Rezoning Transportation Analysis
Petition Number: Insert Zoning Petition #2021-017
General Location Identifier: Tax ID 08904208

Revision Log:	Date	Description
	02-25-21	First Review (EL)
	03-25-21	Second Review (KP)

TECHINCAL DATA

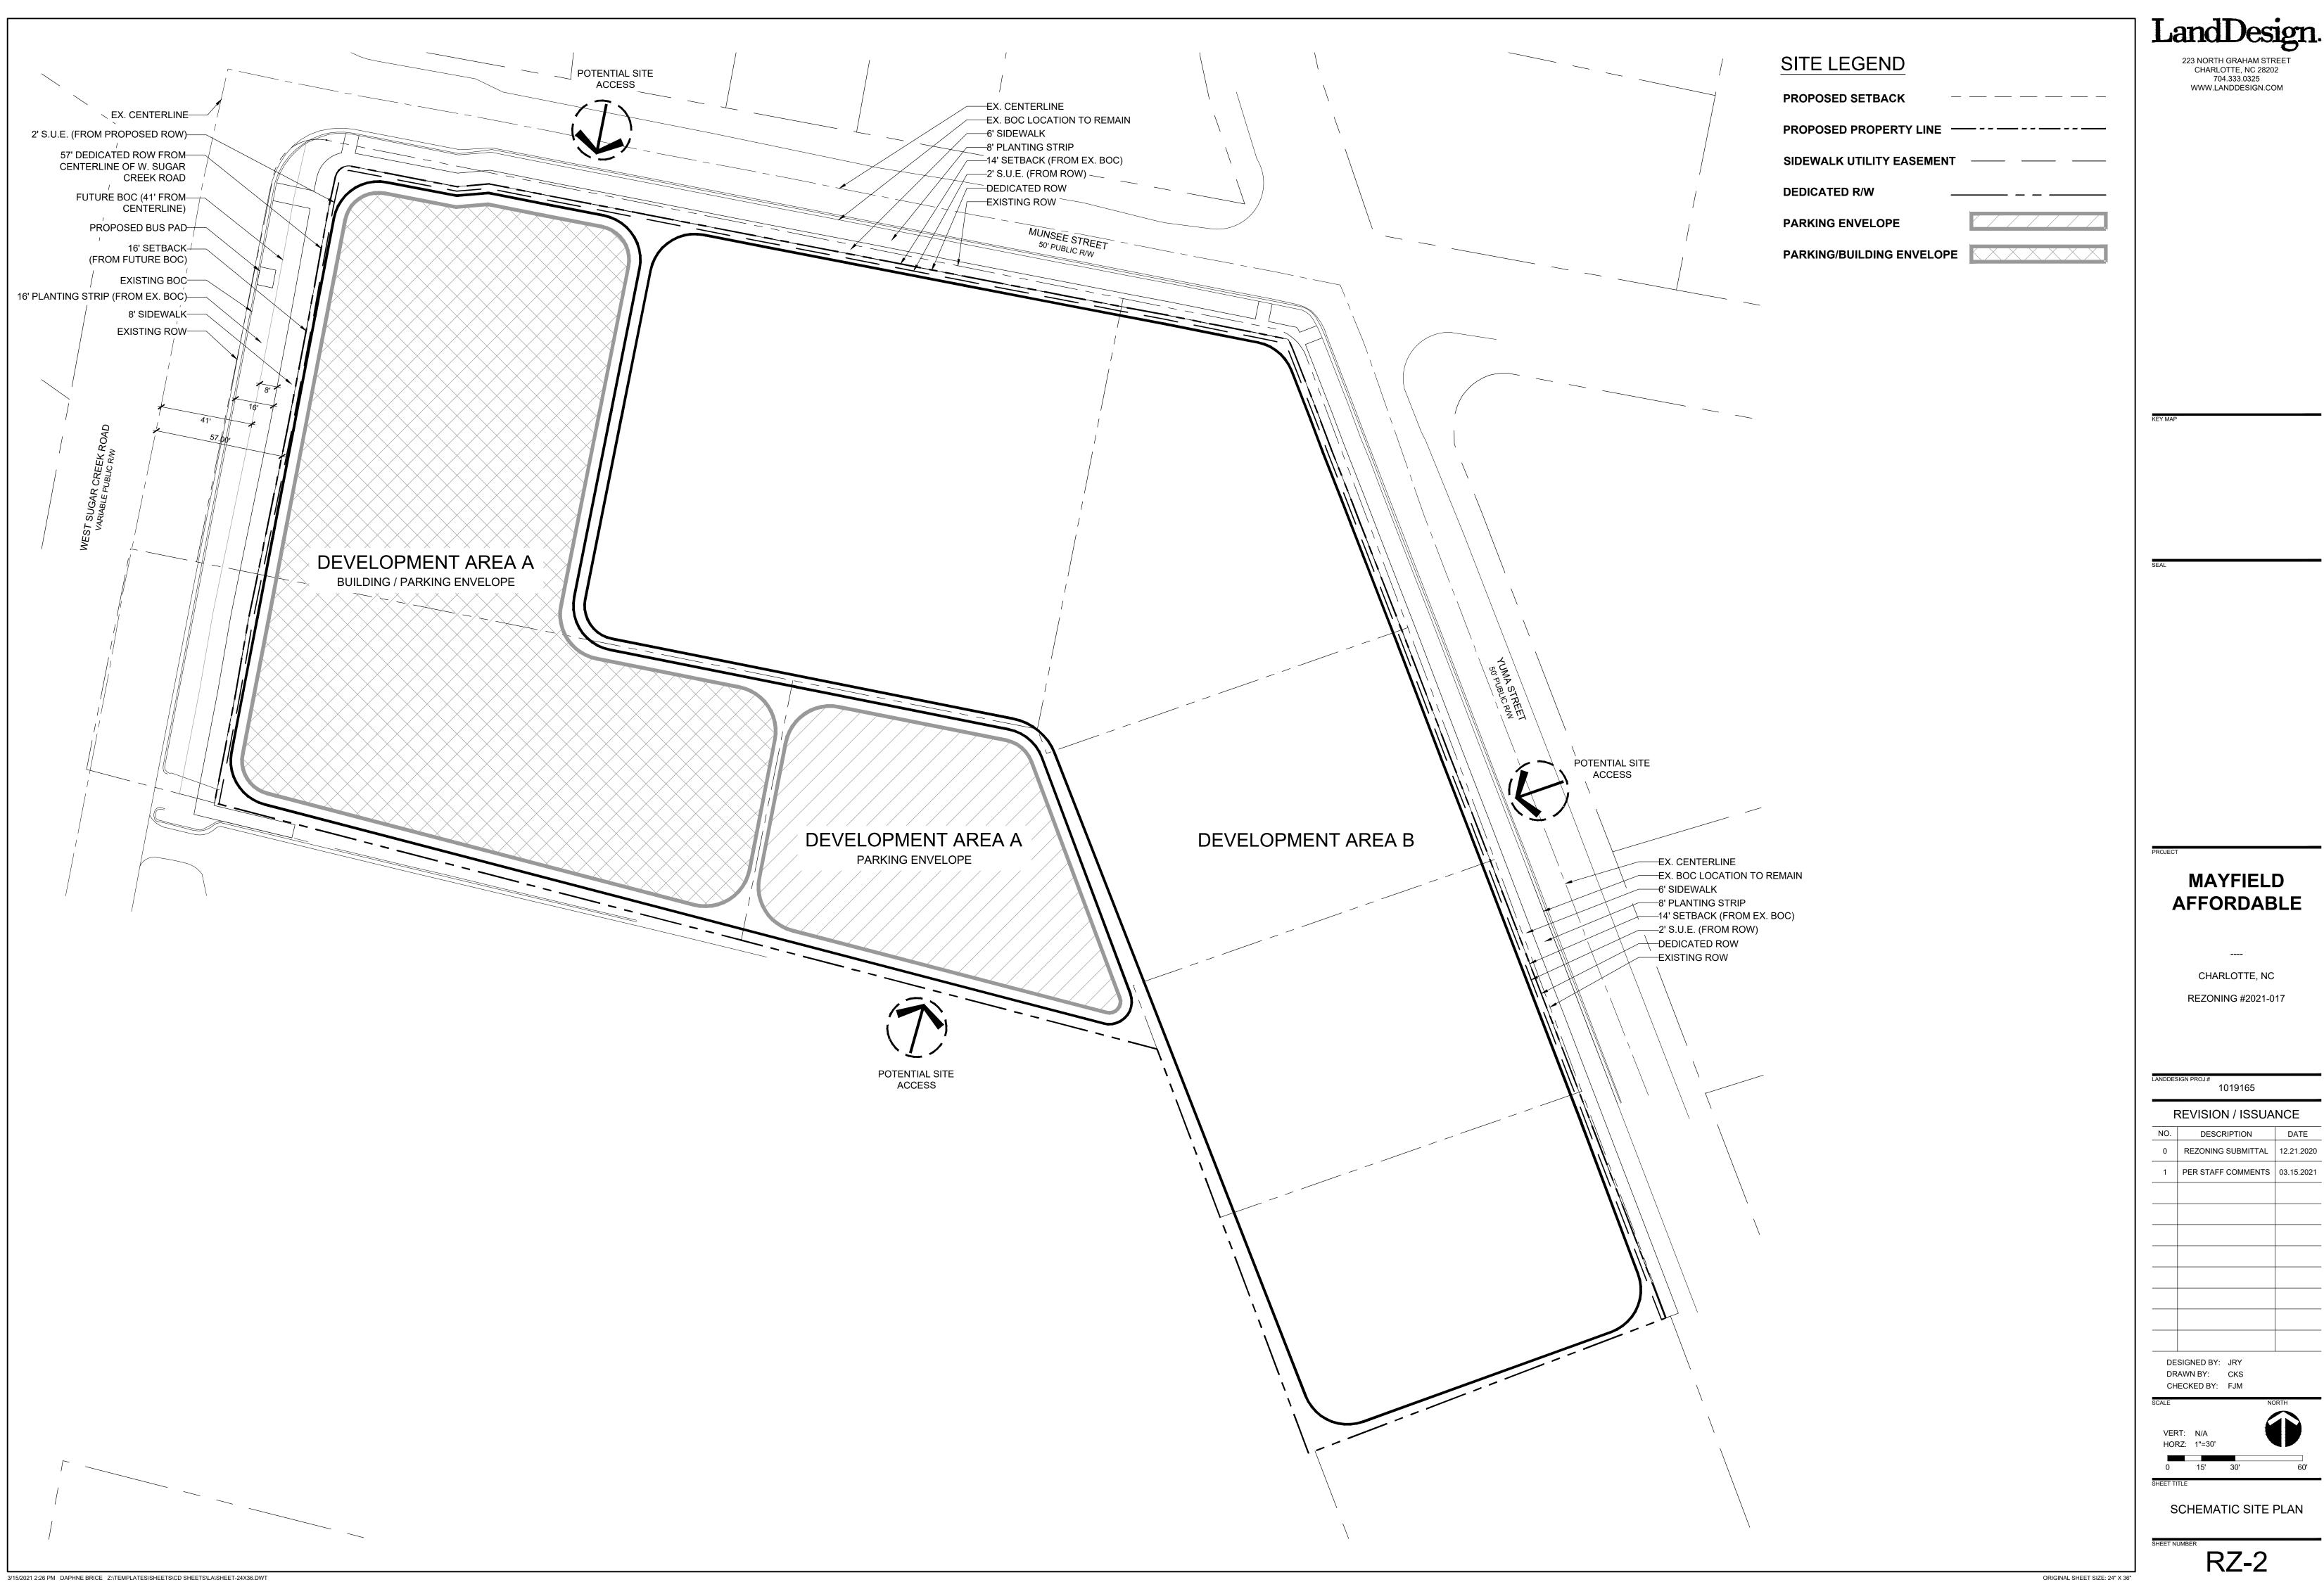
1. **Curblines:** The proposed zoning district has a setback measured from back of the existing or proposed future curblines.
 - a. **Sugar Creek Road:** Location of curb and gutter needs to be relocated to 41-foot from road centerline to back of future curb, to accommodate a future 4+ Boulevard road cross section with buffered/separated bike lanes, in accordance with Charlotte BIKES policy.

Label and dimension the curb and gutter from the centerline for each road on the site plan.

- b. **Munsee Street:** Replace the existing valley gutter for CLDSM standard curb and gutter at the existing edge-of-pavement along the rezoning property frontage. **Update to Comment as a Result of the 03/16/2021 Site Plan:** Revise the back of curb label "To be replaced with CLDSM 10.17A Standard 2'-6" Curb and Gutter"
- c. **Yuma Street:** Replace the existing valley gutter for CLDSM standard curb and gutter at the existing edge-of-pavement along the rezoning property frontage. **Update to Comment as a Result of the 03/16/2021 Site Plan:** Revise the back of curb label "To be replaced with CLDSM 10.17A Standard 2'-6" Curb and Gutter"

4. The proposed dwelling units exceeds 12 per acre. Per Chapter 20: Subdivision Ordinance, site plan and conditional note(s) revisions are needed to commit to construct an 8-foot planting strip and 8-foot sidewalk along all public street road frontages; currently the site plan shows this for W Sugar Creek Rd only. The wider sidewalk also meets the Charlotte WALKS Policy.

Update to Comment as a Result of the 03/16/2021 Site Plan: 8-foot sidewalk required on all frontages. Revise the site plan to incorporate the 8-foot sidewalk on Yuma Street and Munsee Street.

6. **Outstanding:** Site plan and conditional note(s) revisions are needed to revise conditional note (Section 4.a.) to provide a recorded access easement with the owner of PID (08904203).

Either provide a cross access easement deed book or page number with the adjacent property owner or clarify that a cross access easement will be pursued with PID 08904203

Update to Comment as a Result of the 03/16/2021 Site Plan: Revise note 4.a to read "Access to the site will be from Munsee Street and Yuma Street. Pending acquisition of a cross-access easement from Mayfield Memorial Baptist Church (PID 08904203), additional access may be provided in the form of an internal driveway connection"
